Response to Submission comments – Kemps Creek Warehouse, Logistics and Industrial Facilities Hub (SSD 9522)

Thank you for your Major Projects Planning Portal referral dated 12 August 2020, seeking WaterNSW's comments on the Response to Submissions (RTS) for State Significant Development (SSD 9522) Kemps Creek Warehouse, Logistics and Industrial Facilities Hub at 657-769 Mamre Rd, Kemps Creek.

Appendix 1 – WaterNSW comments SSD 9522 RTS

SOUTHERN LINK ROAD - ALIGNMENT PLAN
SCALE 1:2500

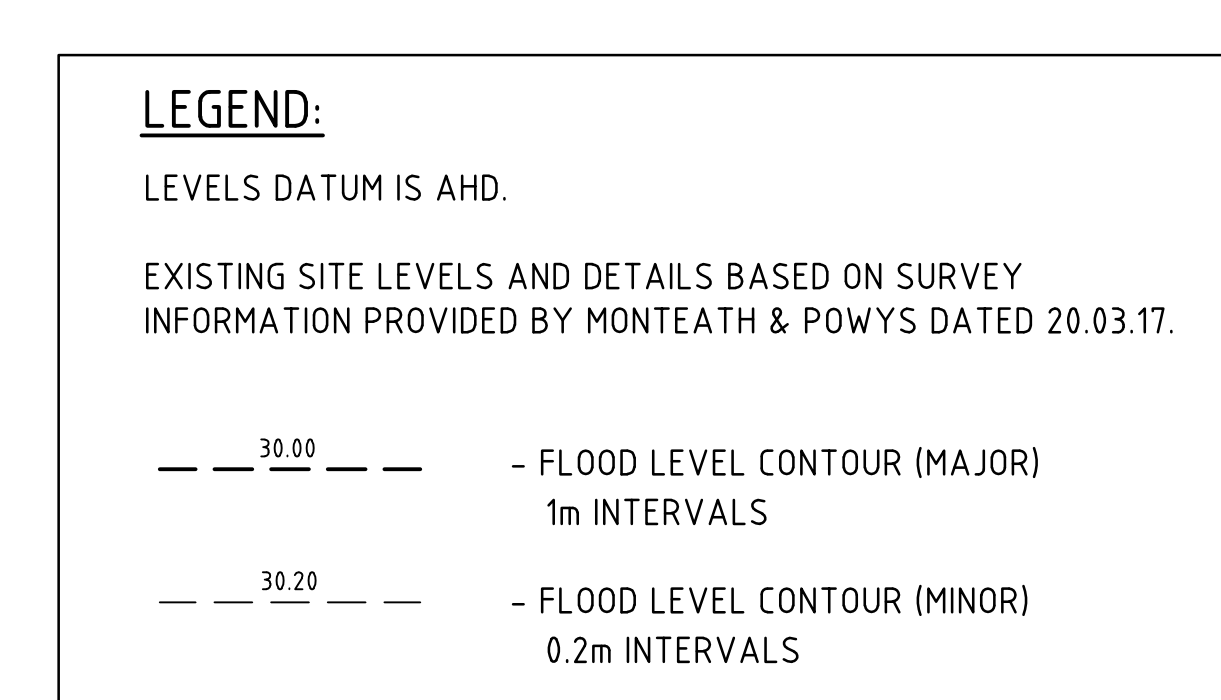
In addition, whilst not part of this development consent, WaterNSW advises that it does not support the Southern Link road alignment (Option 3) that crosses the Warragamba Pipelines Corridor as depicted on plan Co13362.00-DA700.
